From: Amanda Scholes on behalf of Planning.Responses
Sent: 22 March 2018 11:48
To: Planning Scanning
Subject: FW: Planning Consultation on: F/5/18/RES
Attachments: Drainage - Supplementary Guidance Notes.pdf

APPLICATION F/5/18/RES

Site Address: Land South of Burndell Road Yapton BN18 0HR

Description of Works: Approval of reserved matters following outline consent F/7/15/OUT relating to appearance, landscaping, layout & scale for residential development comprising of 45No. dwellings. This application also lies within the parish of Yapton. Resubmission of F/23/16/RES

This drawing contains:
Topo = (February-14-2018) 13:4718
Layout = (February-22-2018) 1000 1.01 Rev P5

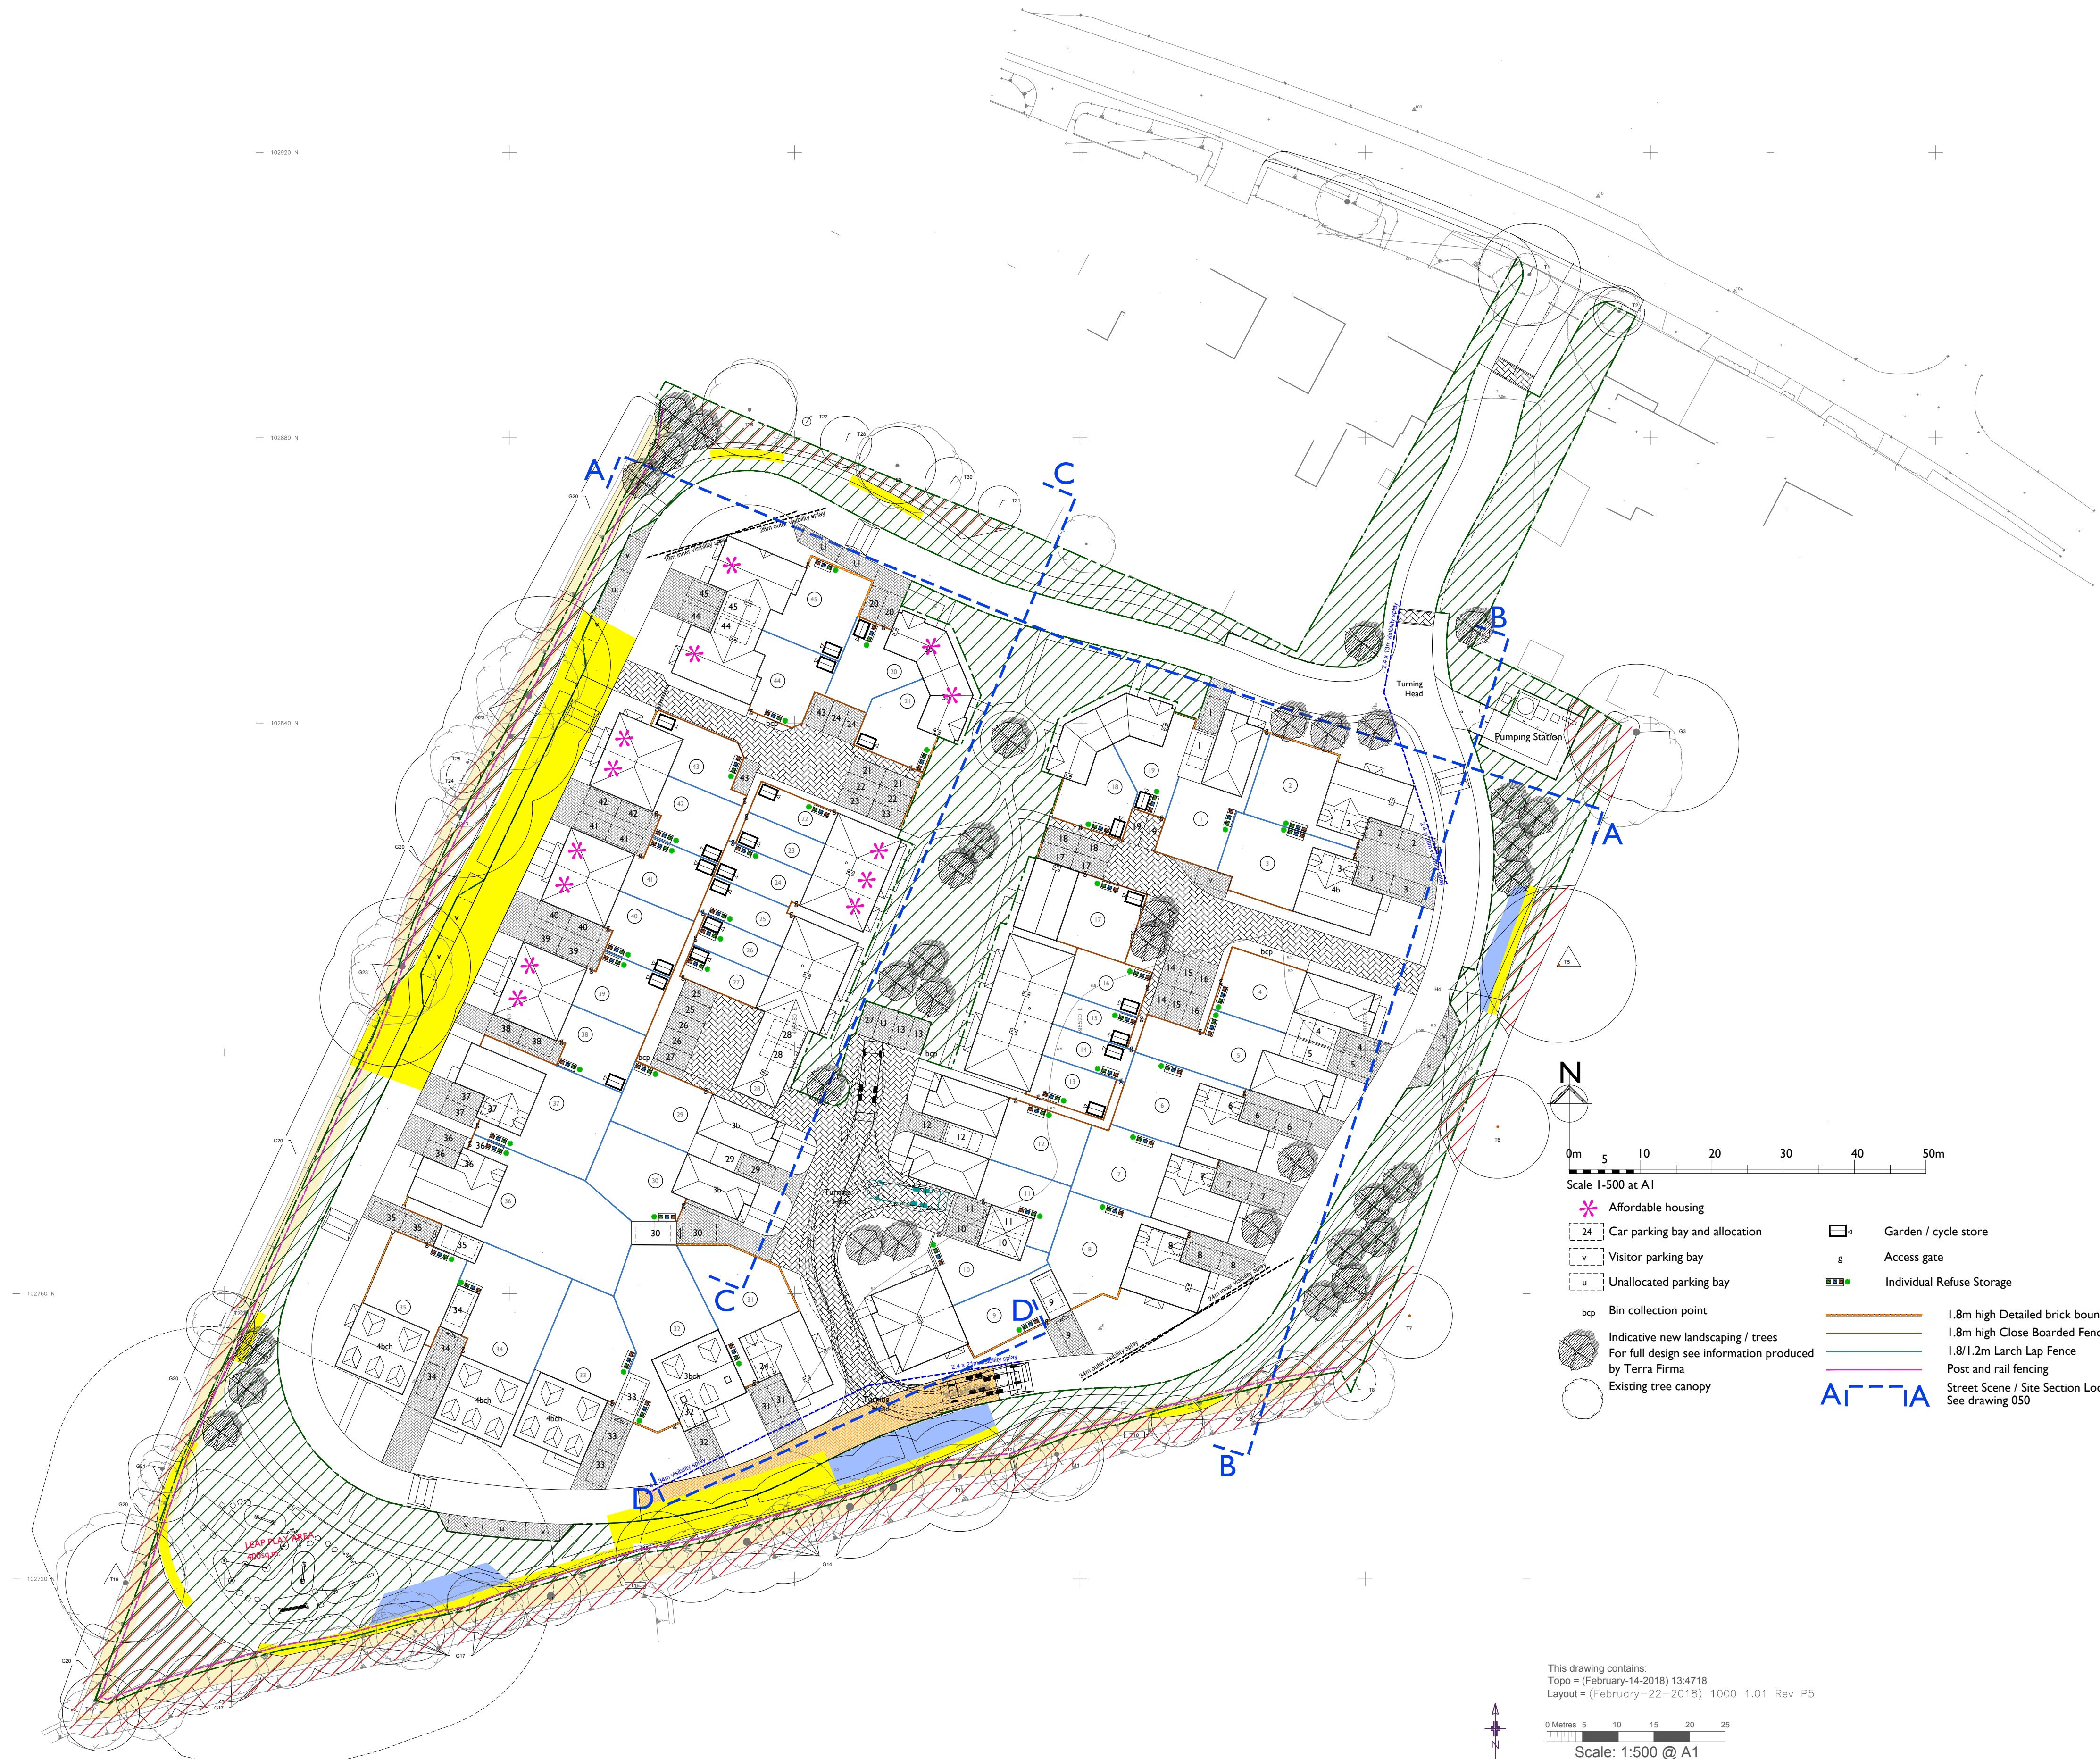
We note that the area previously outlined for the location of a pond in the application F/7/15/OUT is now to contain a play area, and that tanks are to be utilised instead. Our preference is for the use of detention ponds over tanks as they are easier to maintain and provide amenity.
